**To: All Staff**  
**From: Environmental Health**  
**Date: 5/15/2026**  
**Subject: SP-26-00003 Miller**

MILLER SHORT PLAT		
PREPARED FOR DON MILLER		
A PORTION OF SECTION 4 & SECTION 33, TWN. 19 N., RGE. 15 E. & TWN. 20 N., RGE 15 E., W.M.		
KITTITAS COUNTY WASHINGTON		
DWN BY <b>G.W.</b>	DATE <b>04/2026</b>	JOB NO. <b>230053</b>
CHKD BY <b>D.L.P.</b>	SCALE <b>1" = 200'</b>	SHEET <b>2 OF 3</b>

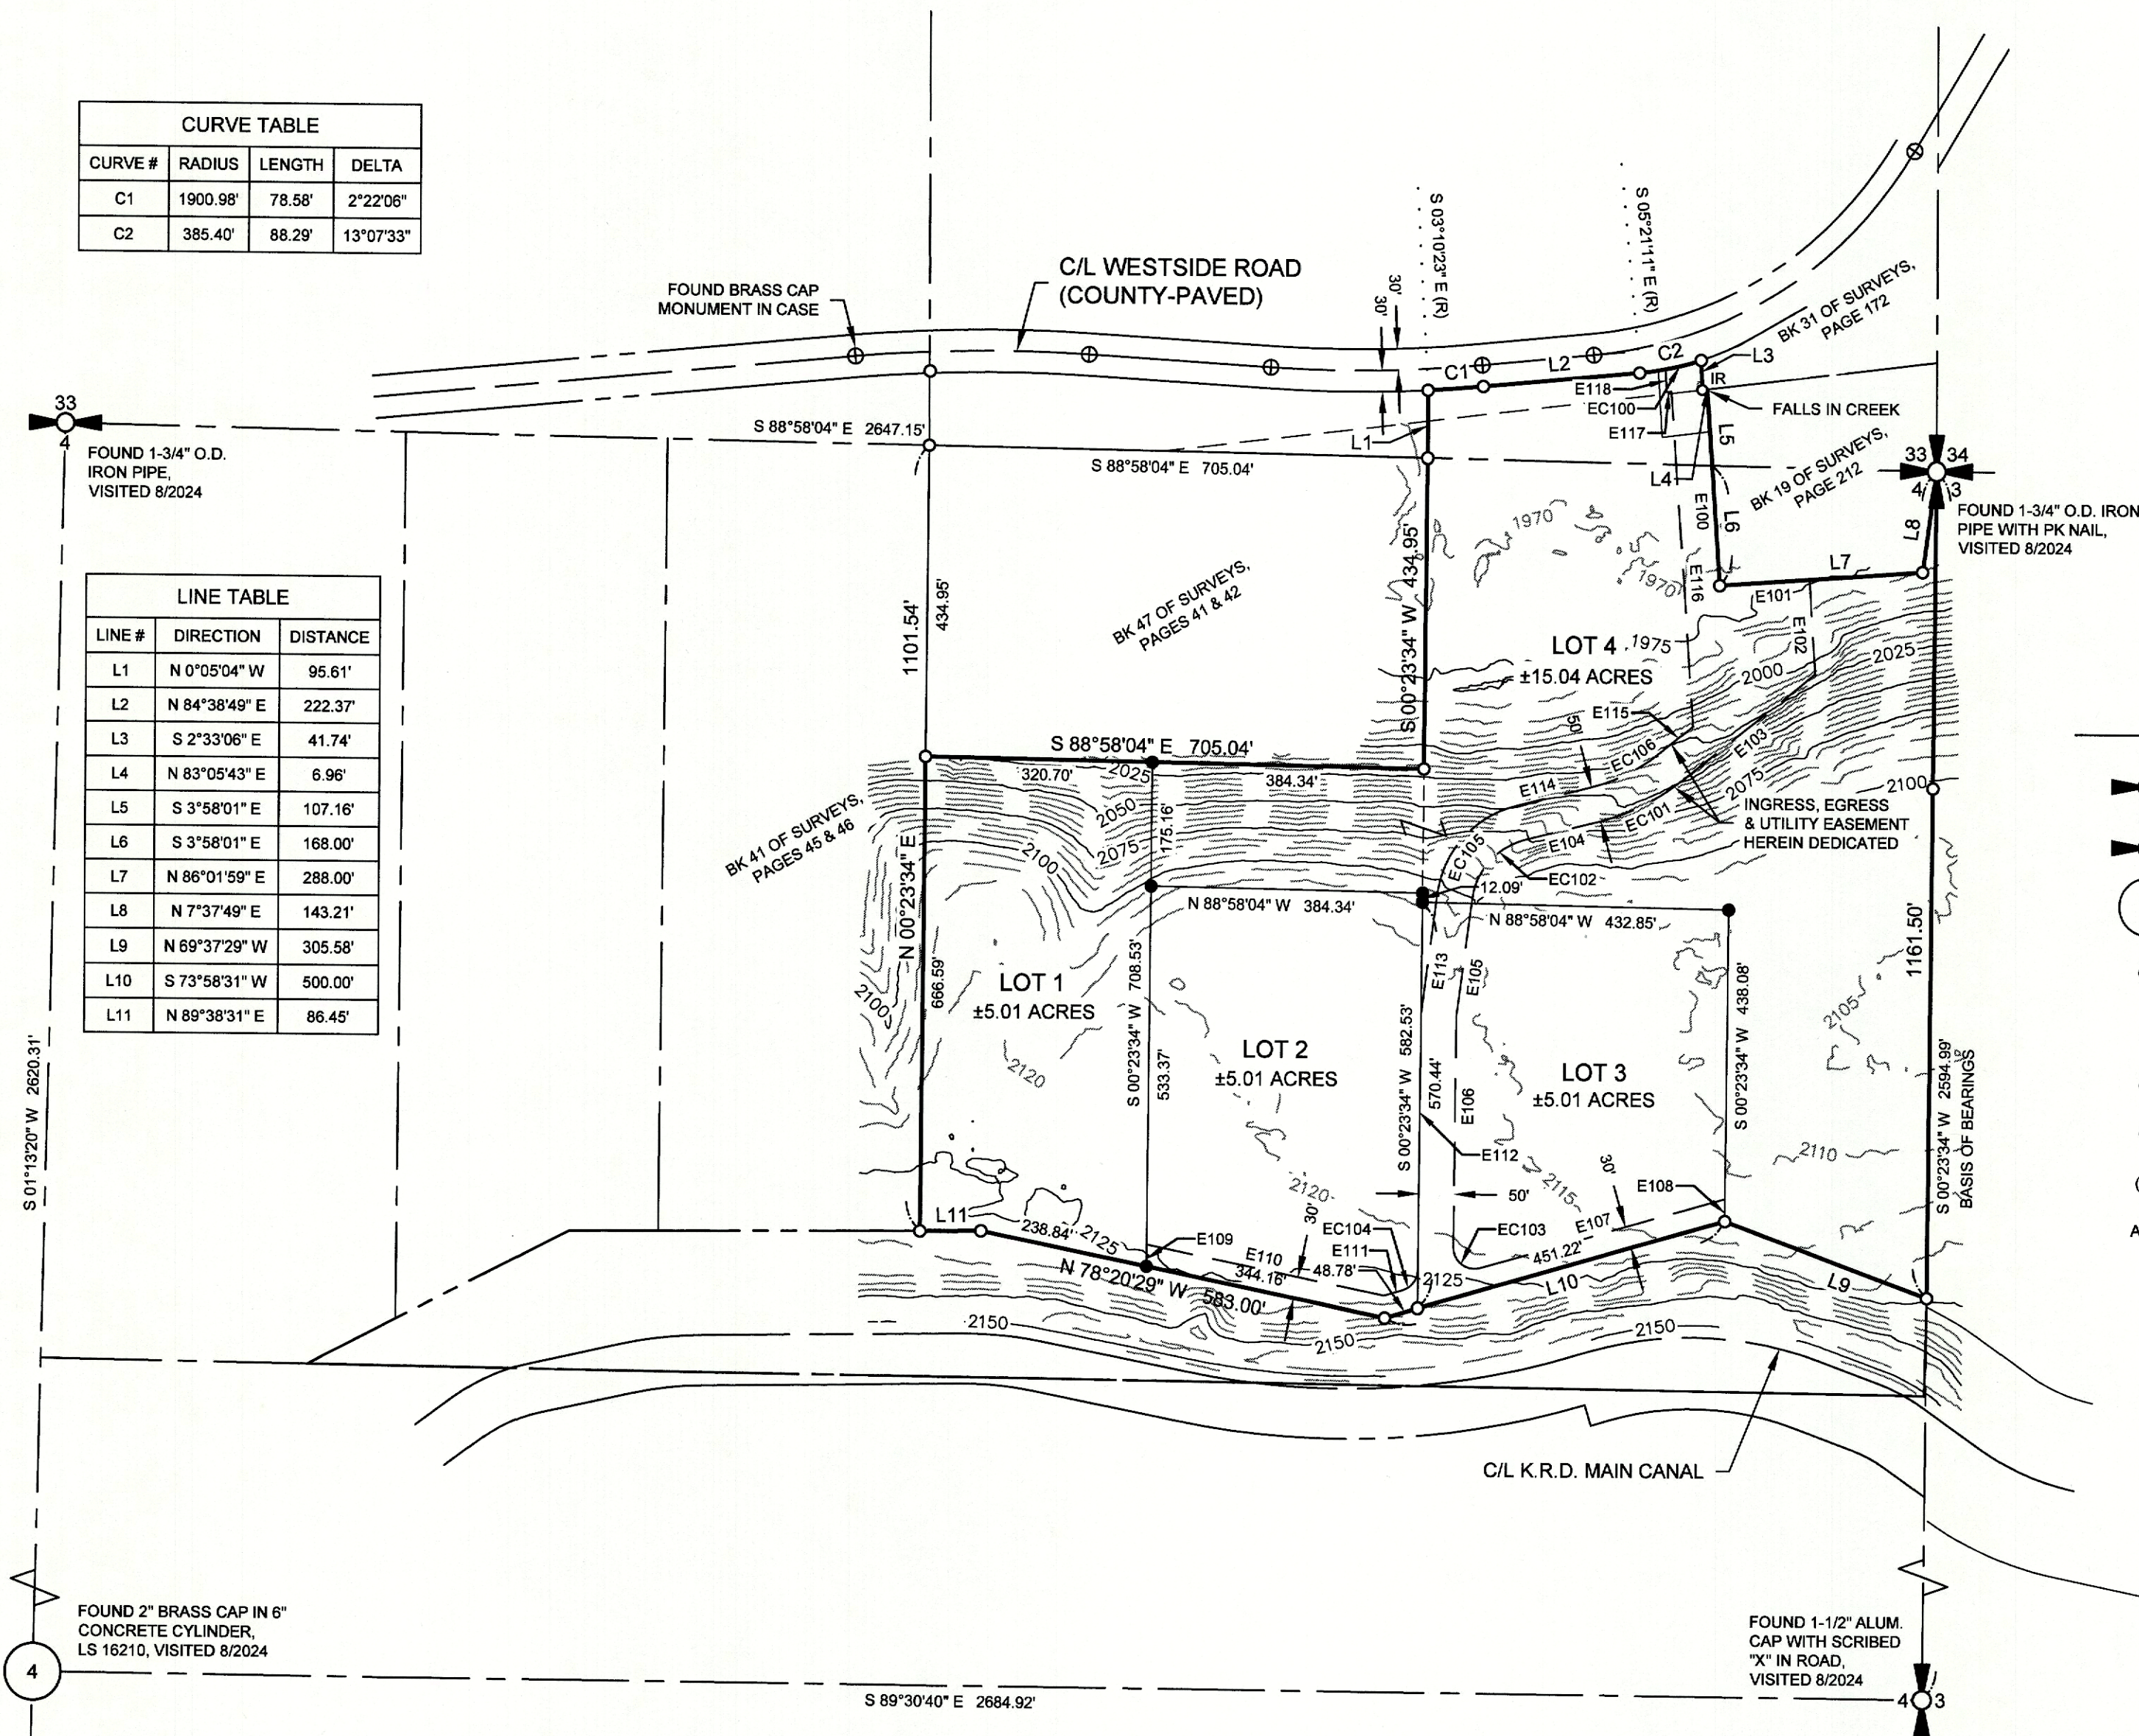
<p><b>Drinking Water</b></p>	<ul style="list-style-type: none"> <li>• Pursuant to KCC 13.35.020, an Adequate Water Supply Determination (AWS D) is required prior to final plat approval for all lots proposing individual and/or shared well water systems.             <ul style="list-style-type: none"> <li>○ Individual wells shall comply with KCC 13.35.050, including demonstration of adequate water quantity and submission of nitrate and coliform water quality results.</li> <li>○ Shared wells shall comply with KCC 13.35.060, including demonstration of adequate water quantity, submission of nitrate and coliform water quality results, and a recorded Shared Well Users Agreement.</li> </ul> </li> <li>• Additional flow equalization, storage, treatment, engineering, and recording requirements may apply depending on well production and water quality results.</li> <li>• A water supply protection zone with a minimum 100-foot radius shall be provided for each existing and proposed well site, consistent with WAC 246-272A-0320.</li> </ul>

<p><b>Wastewater</b></p>	<ul style="list-style-type: none"> <li>• Prior to preliminary plat approval, the applicant shall perform a site evaluation in accordance with WAC 246-272A-0220 to demonstrate that the proposed lots are capable of supporting conforming on-site sewage systems and required reserve areas. The evaluation shall include a minimum of two soil test pits per lot within the primary and reserve drainfield areas, and the test pit locations shall be shown on the plat map and flagged in the field for inspection.</li> </ul>
